1.1.1 Velocity Transport Planning (VTP) has been appointed by Firethorn Trust (the Applicant) to provide highways and transport planning advice for an outline planning application relating to the development of up to 530 dwellings on land which forms part of the North West Bicester Eco Town development (Policy Bicester 1 of the adopted CDC Local Plan), located in Oxfordshire.

1.1.2 The Proposed Development description for the outline planning application, planning reference: 21/01630/OUT, is as follows:

# TECHNICAL NOTE: RESPONSE TO OCC COMMENTS

REVISION DETAILS		
DRAWING NO.		
<b>4600-1100-T-011</b>		
DRAWN	APPROVED	DATE
EP	MP	JAN 21
SCALE		REV
AS SHOWN @ A3		E

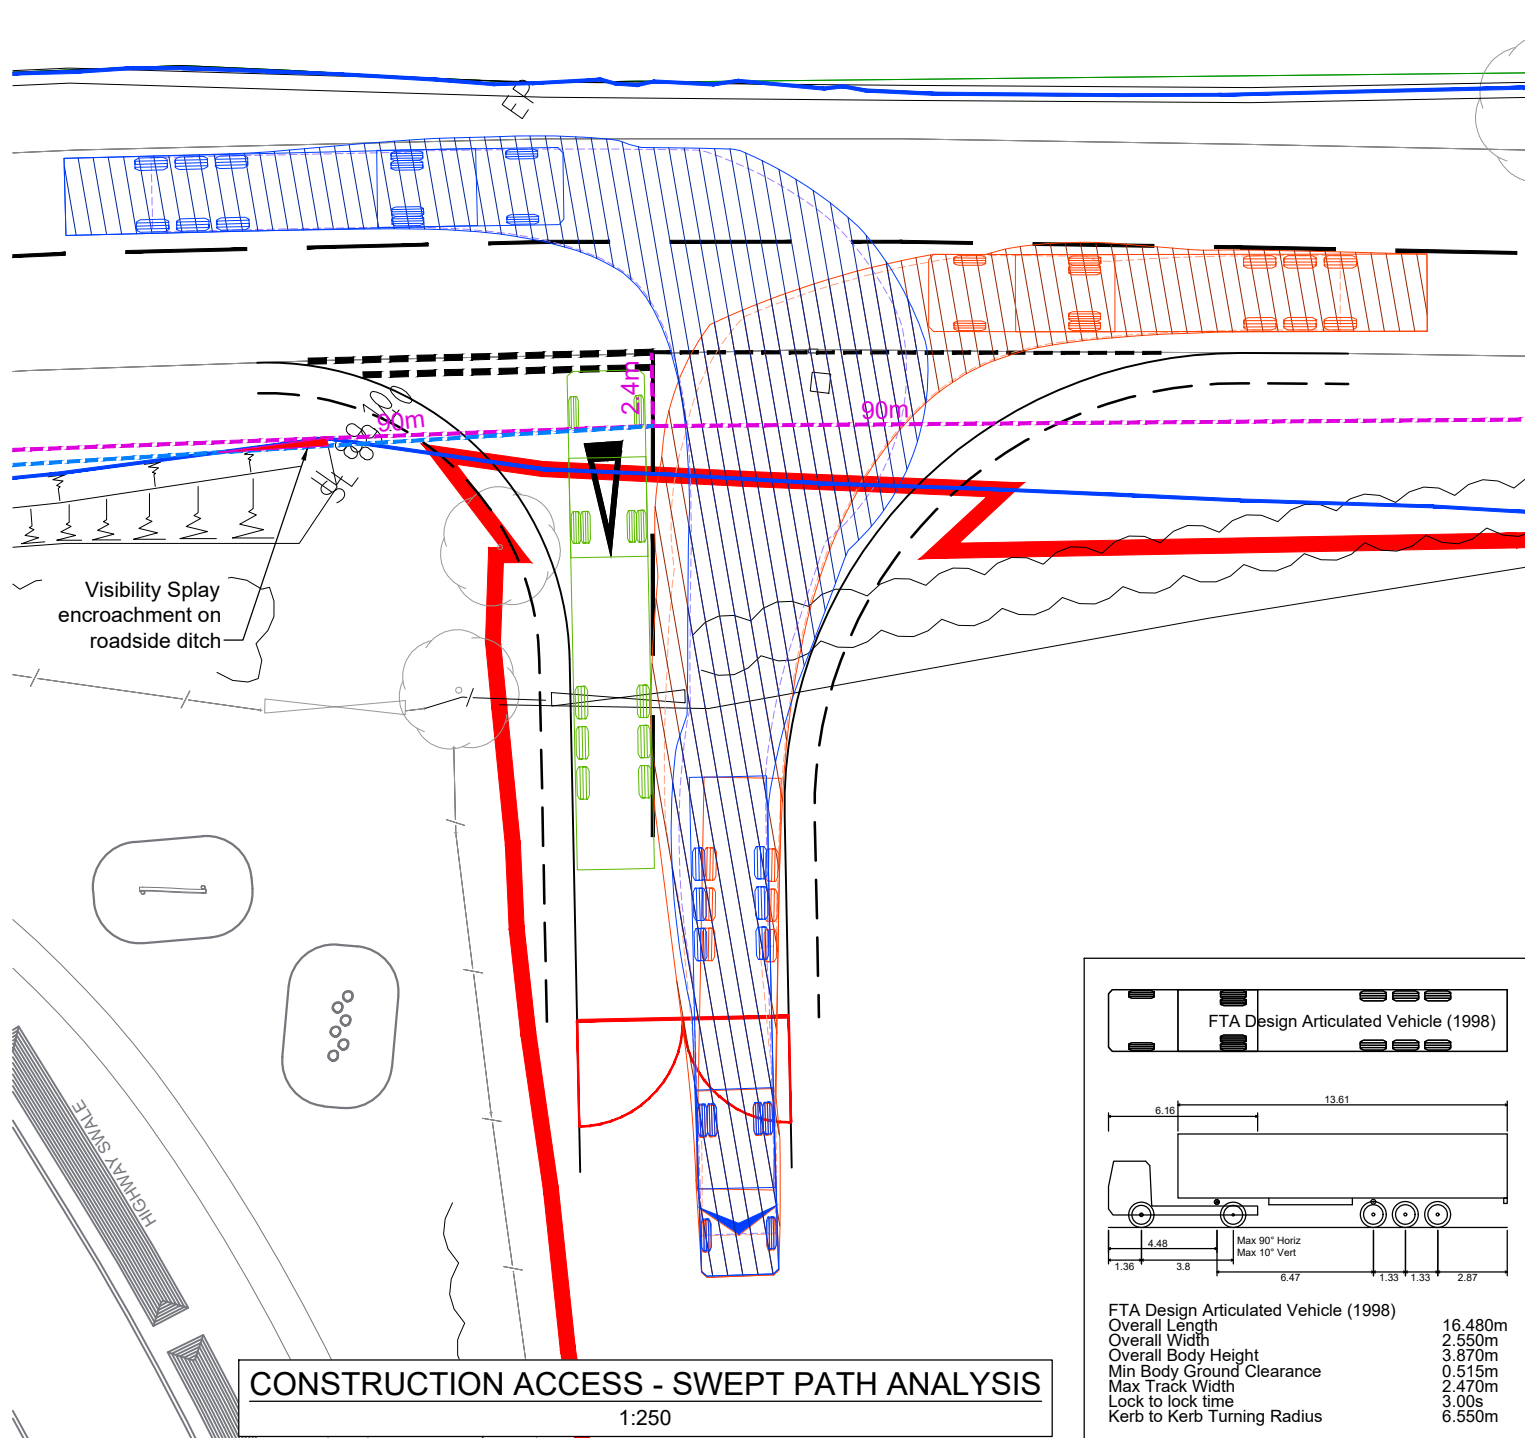
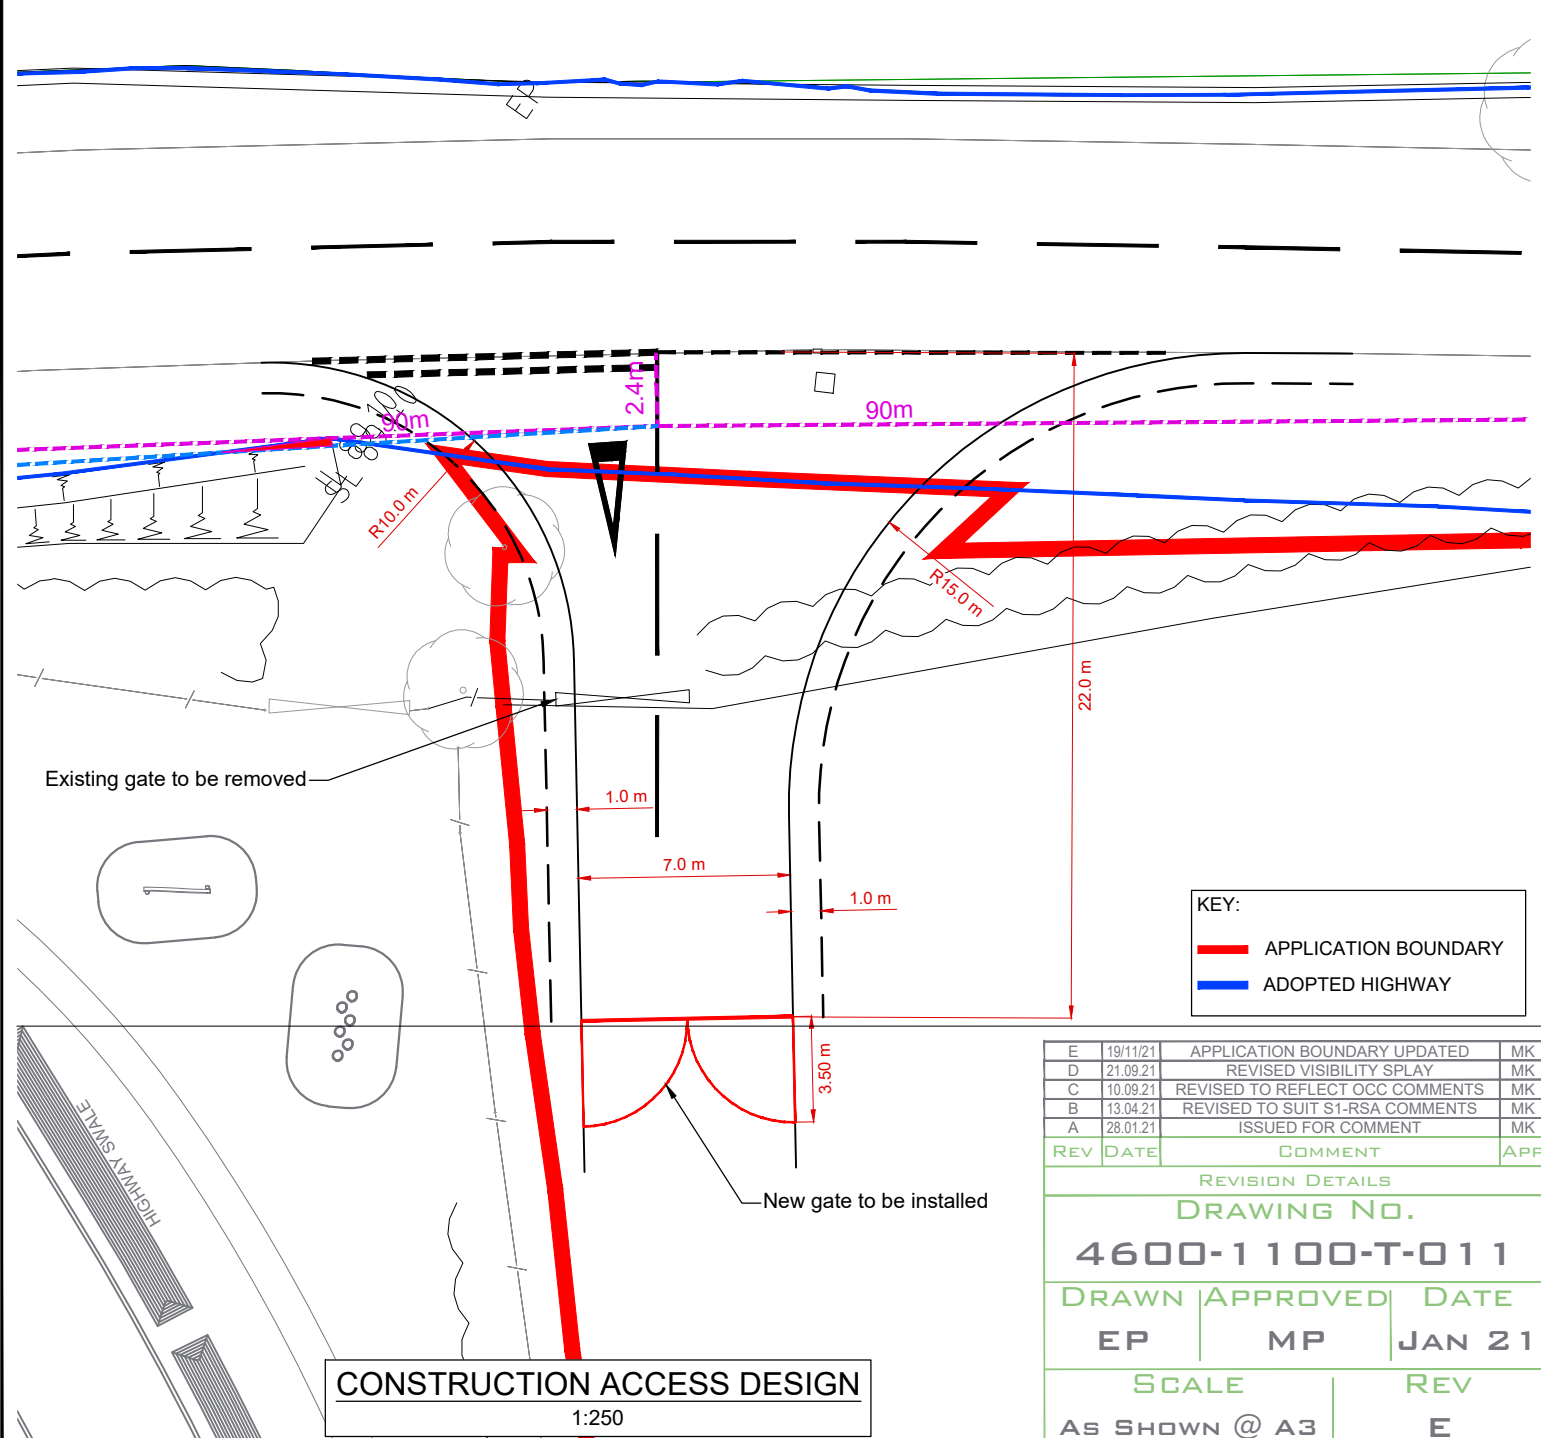
3.3.1 It is acknowledged that the existing speed limit along the B4100 in the vicinity of the proposed temporary construction access to the eastern parcel is 40mph. In accordance with DMRB, this would require a junction visibility splay of 2.4m x 90.0m. VTP Drawing 4600-1100-T-011 Rev F, a copy of which is included at **ATTACHMENT B**, identifies that this visibility can be achieved towards the east, but due to the existing drainage ditch located to the immediate west of the proposed temporary access, the visibility splay is compromised.

3.3.2 As set out in the response from OCC, should the speed limit along this stretch of the B4100 be reduced to 30mph, this would require visibility splays of 2.4m x 70.0m, which are shown to be achievable on the updated Proposed Construction Access plan.

DRAWING No.		
4600-1100-T-041		
DRAWN	APPROVED	DATE
EP	MK	JAN 22
SCALE		REV
1:500 @ A3		A

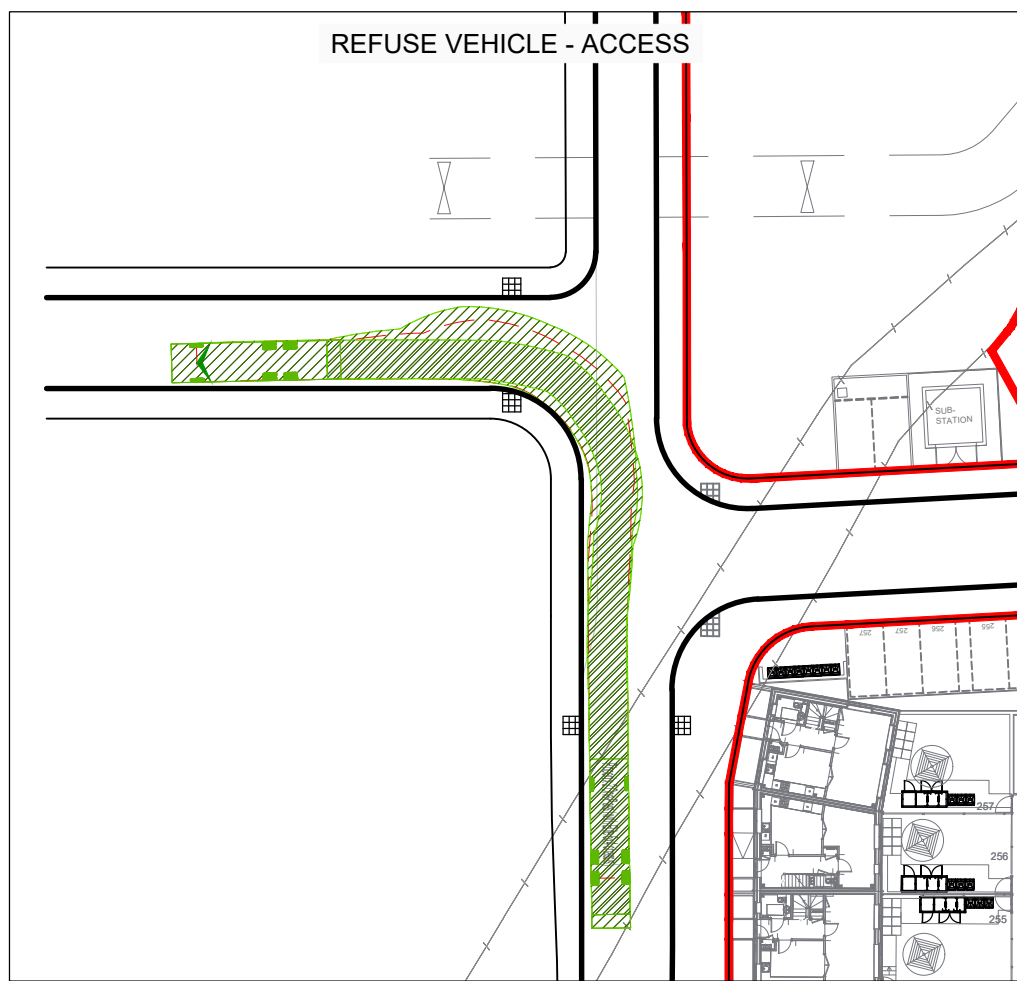
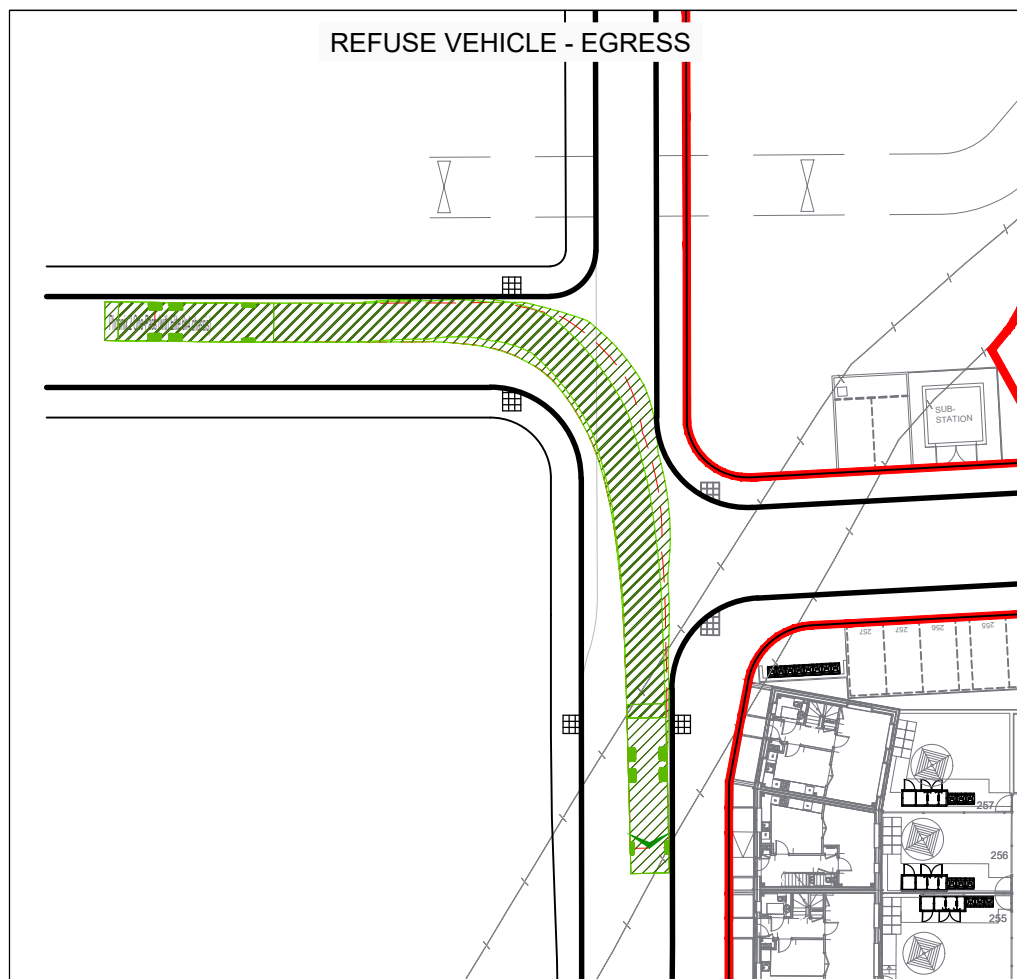
3.2.3 For completeness, VTP Drawing 4600-1100-T-041 Rev A presents the combined site access arrangements for Site Access A & B, which includes details of the swept path assessment for a large refuse vehicle accessing the western parcel, visibility splays, and footway provisions. A copy of this updated Site Access arrangement is included at **ATTACHMENT B**.
